Demolition of existing garage & outbuildings. Alterations to external materials (including change from thatch to clay tiled roof and brick/stone to fibre cement weatherboarding and coloured render). Alterations to existing fenestration, including to 2 no. ground floor rear bay windows, and addition of first floor front dormer, enlarged balcony at first floor level at the rear. Replacement garages.

The Breakers 29 Tamarisk Way East Preston

Thank you for your internet representation made on 11th February 2020 which has been recorded as **'an objection'** with the comments as follows:

Elevations as Proposed

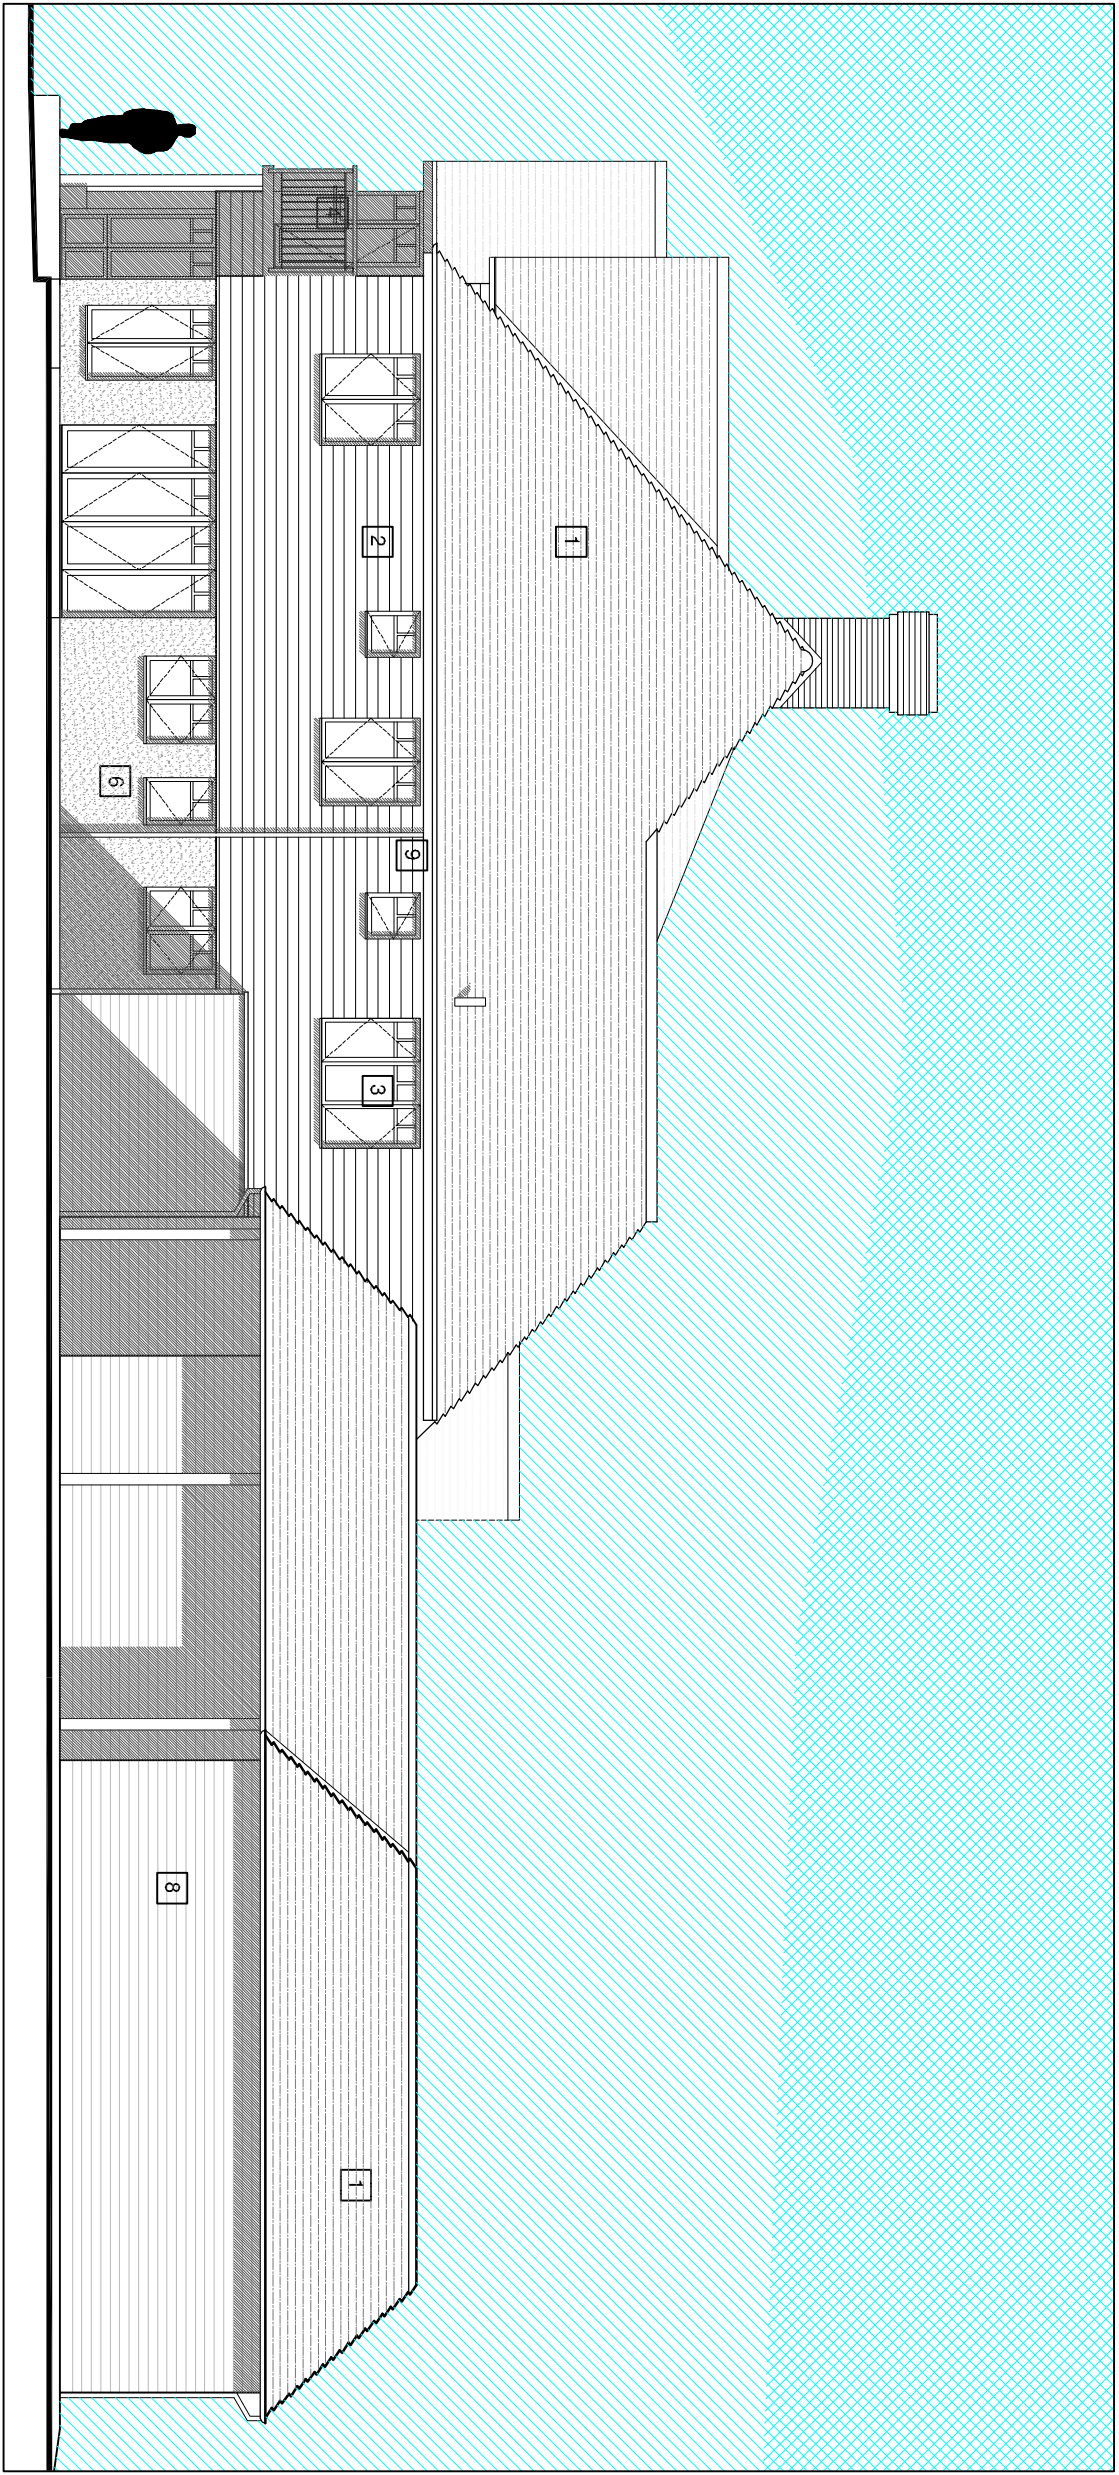
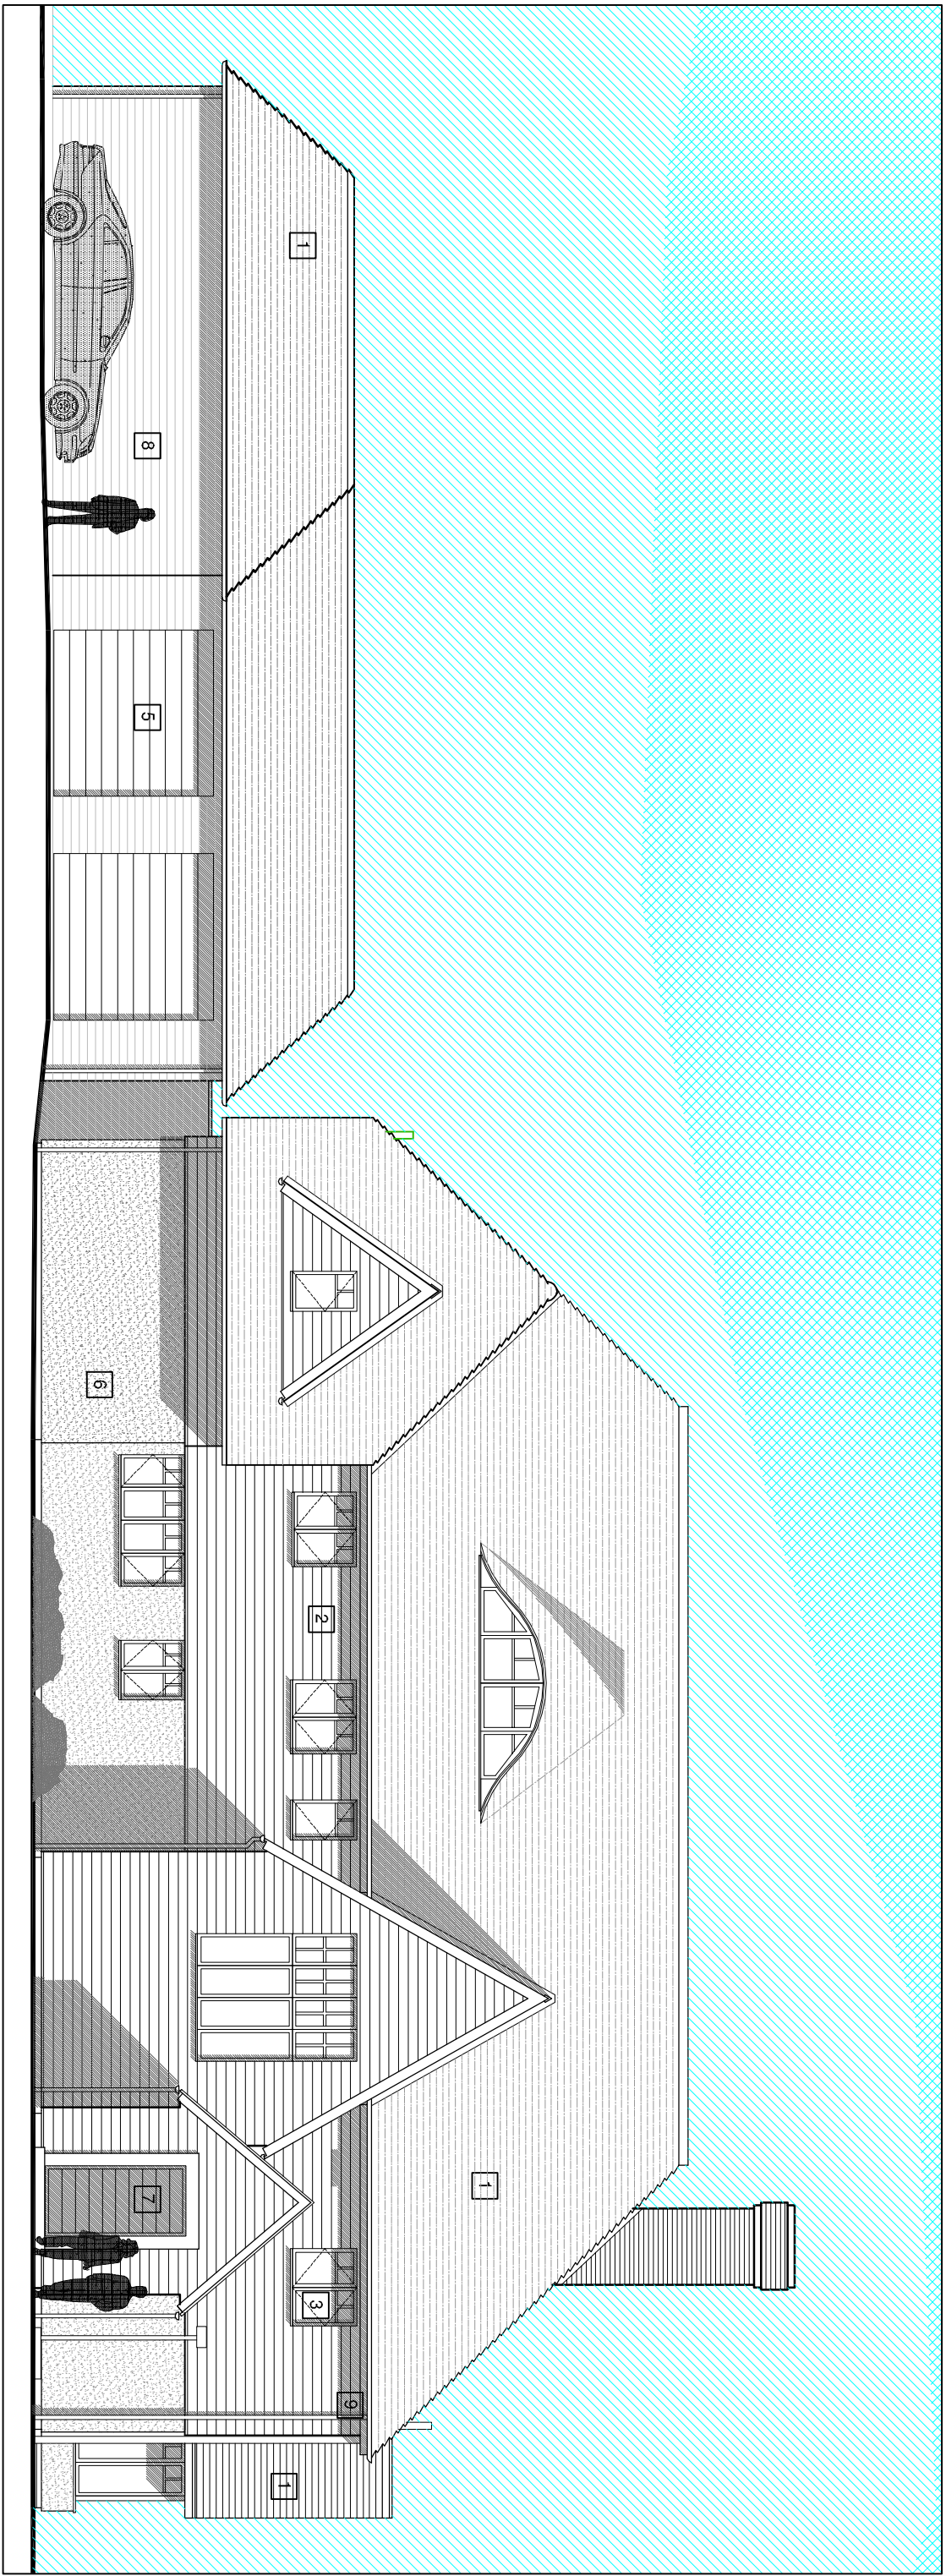
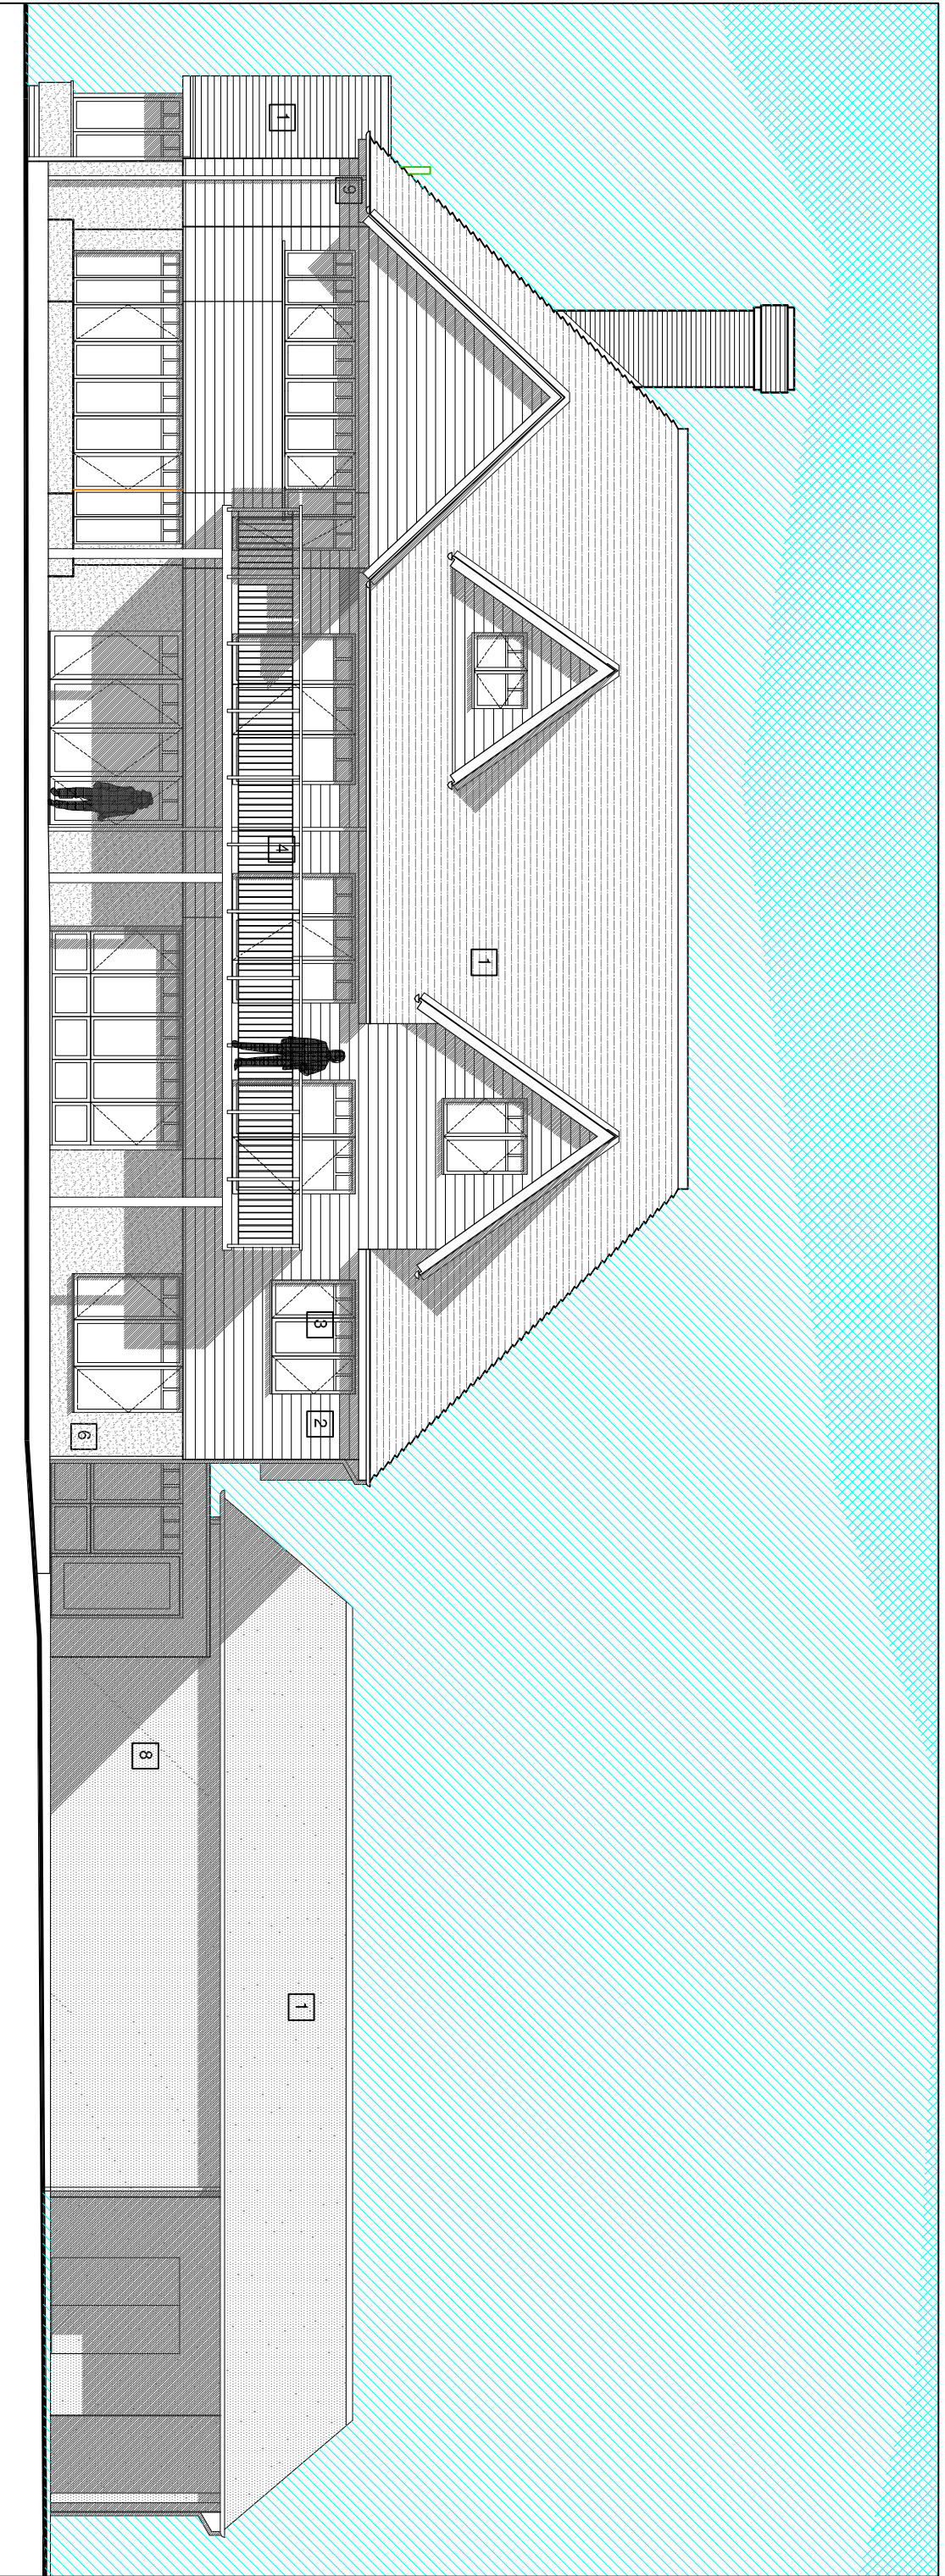
Thatching has been used for centuries and gives excellent thermal insulation, keeping a property warm in winter and cool in summer. It also provides excellent sound insulation and is very strong in high winds, whilst tiles are falling all around. As for fire risk, a properly constructed thatched roof on a well maintained property with modern electrical installations and sound brickwork around any used chimneys is no more likely to catch fire than a tiled or slate roof. Modern wood burning stoves installed into chimneys in poor condition is the main risk alongside electrical fault. This particular thatch has stood for nearly 100 years with no problem.
